DECISION DELEGATED TO DEVELOPMENT MANAGER

Application No: H05-0434-20 **Applicant:** Mr P Vijayaratnam
Proposal: Replace existing porch, new dormer extension and alterations
Location: 24 Fleet Road Fleet Spalding
Terminal Date: 27th August 2020

Drawing Title:
PROPOSED ELEVATIONS

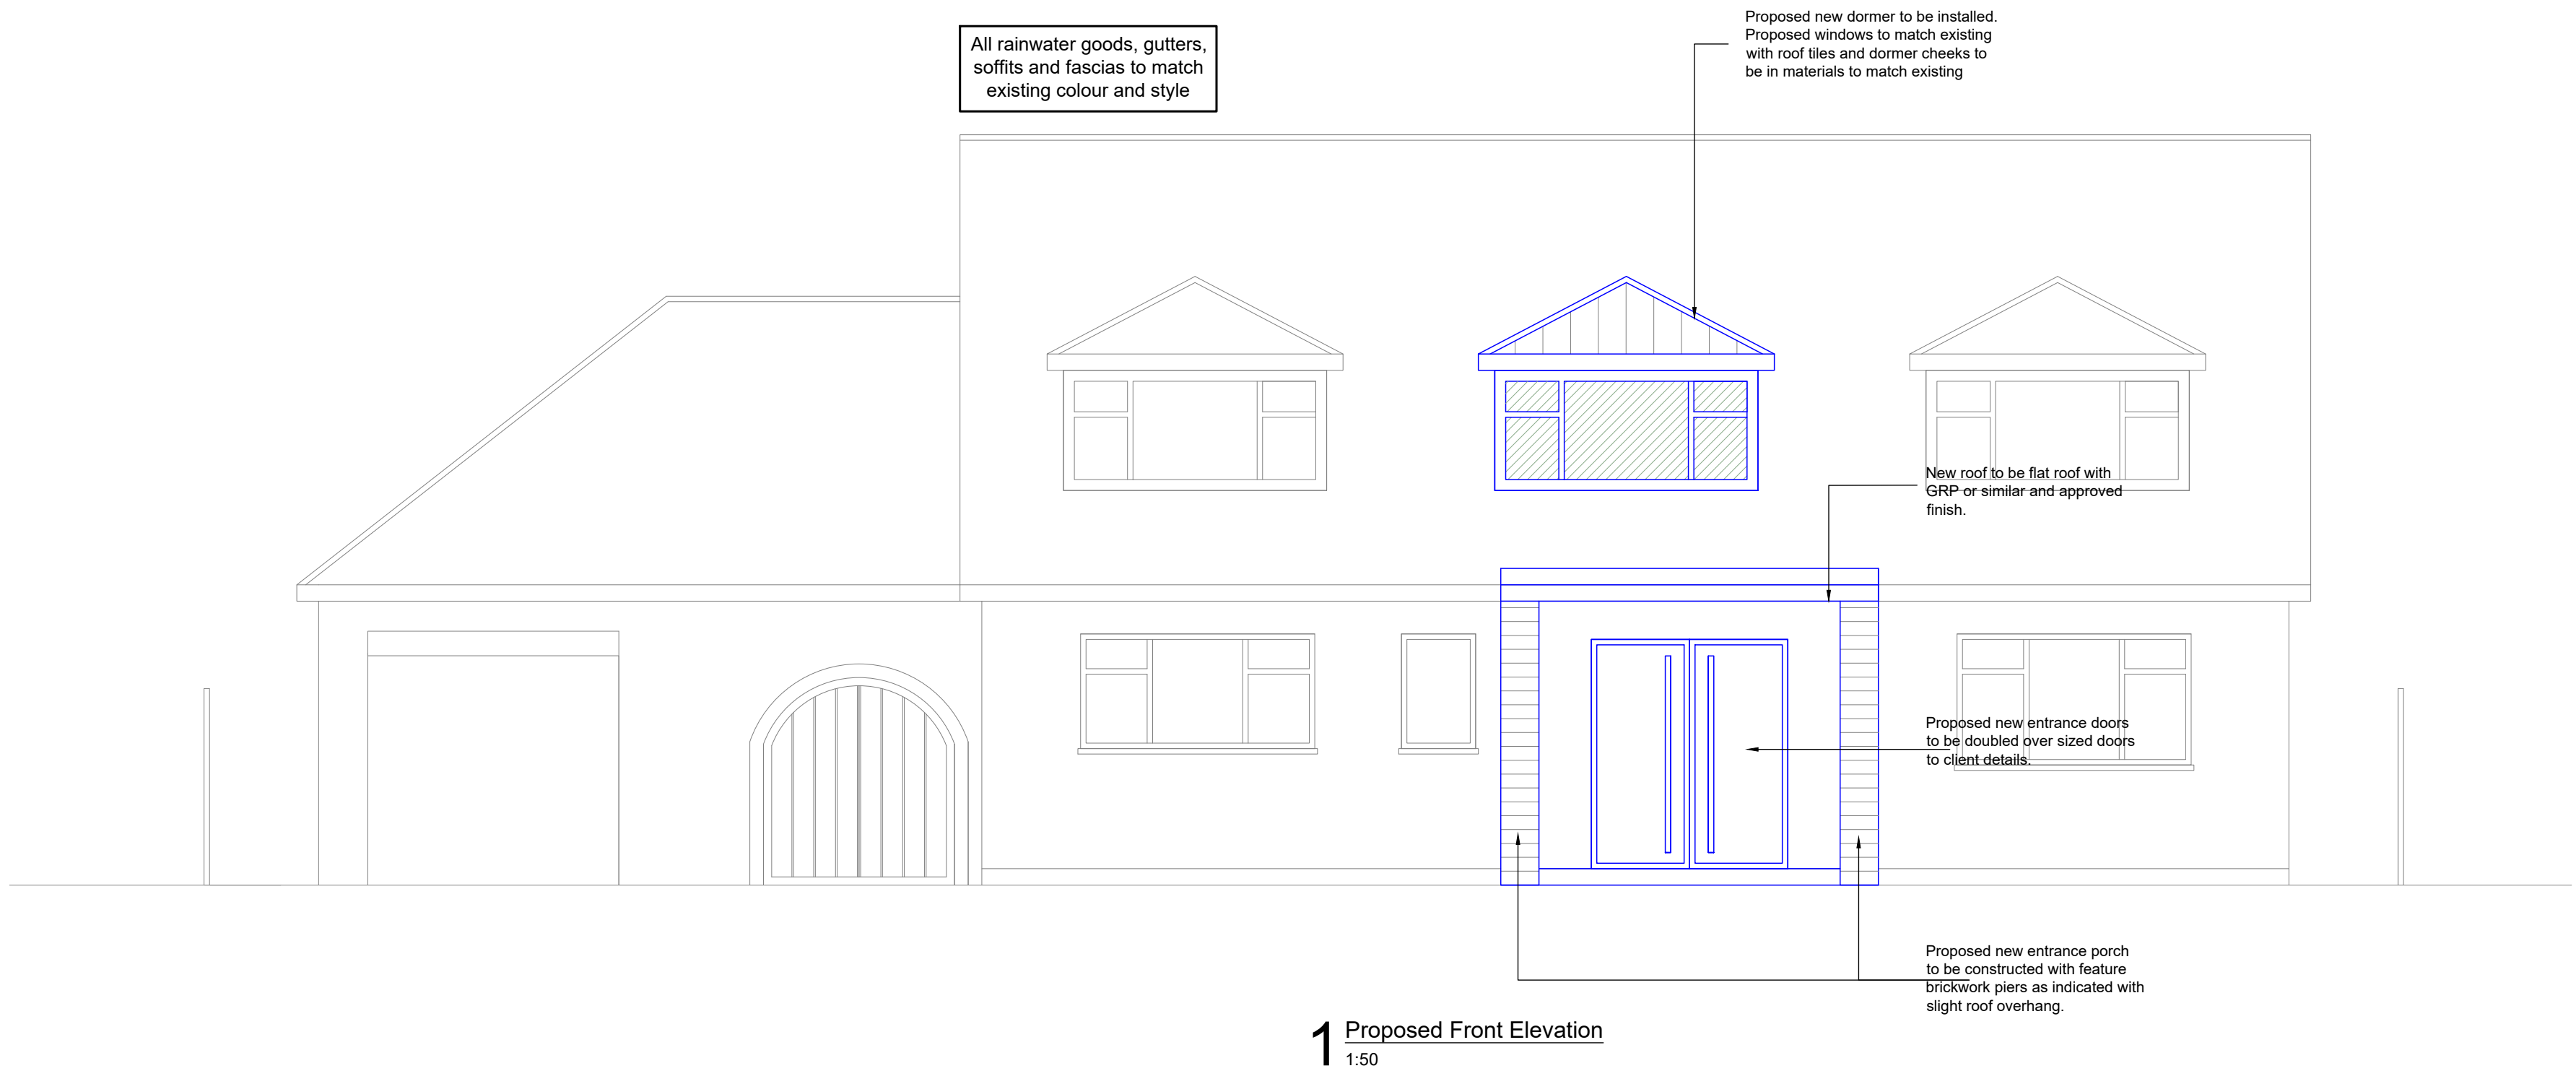
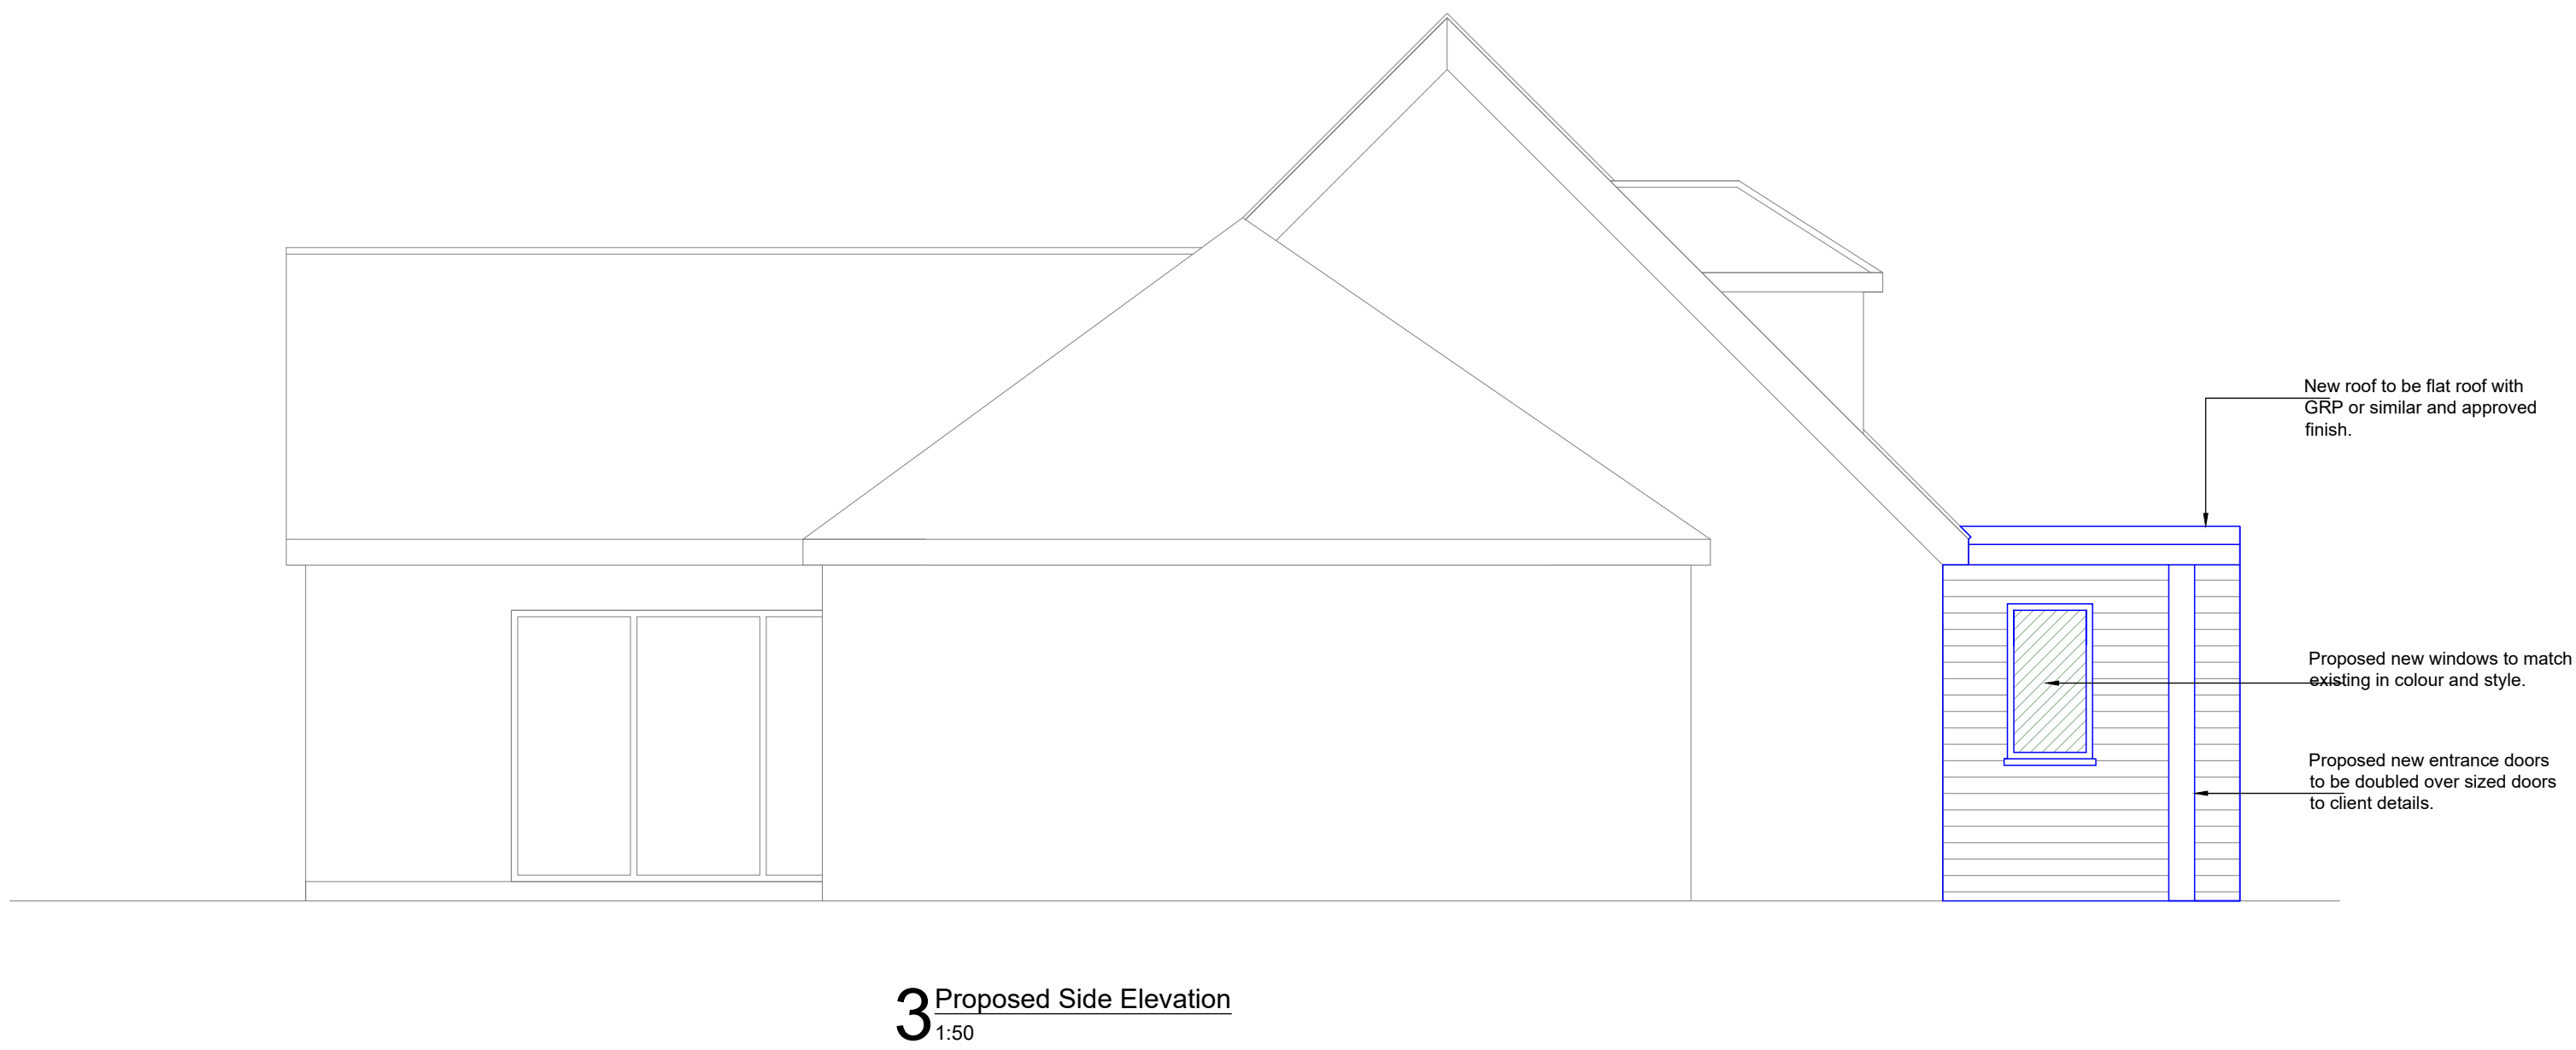
The porch roof will be sustained by two brick piers. The dormer window will have a hip gable pitched roof as the existing roof openings. The window layout will replicate those existing. The external materials of both porch and dormer will match those existing in the property, thereby the visual amenity will not result undermined.

The creation of one further dormer window will entail no adverse effect on the external fabric of the house neither on the wider street scene. The mixture of architectural elements of the properties of the frontage development is highly varied and the external proposal development will not lead to any cumulative impact in terms of design.
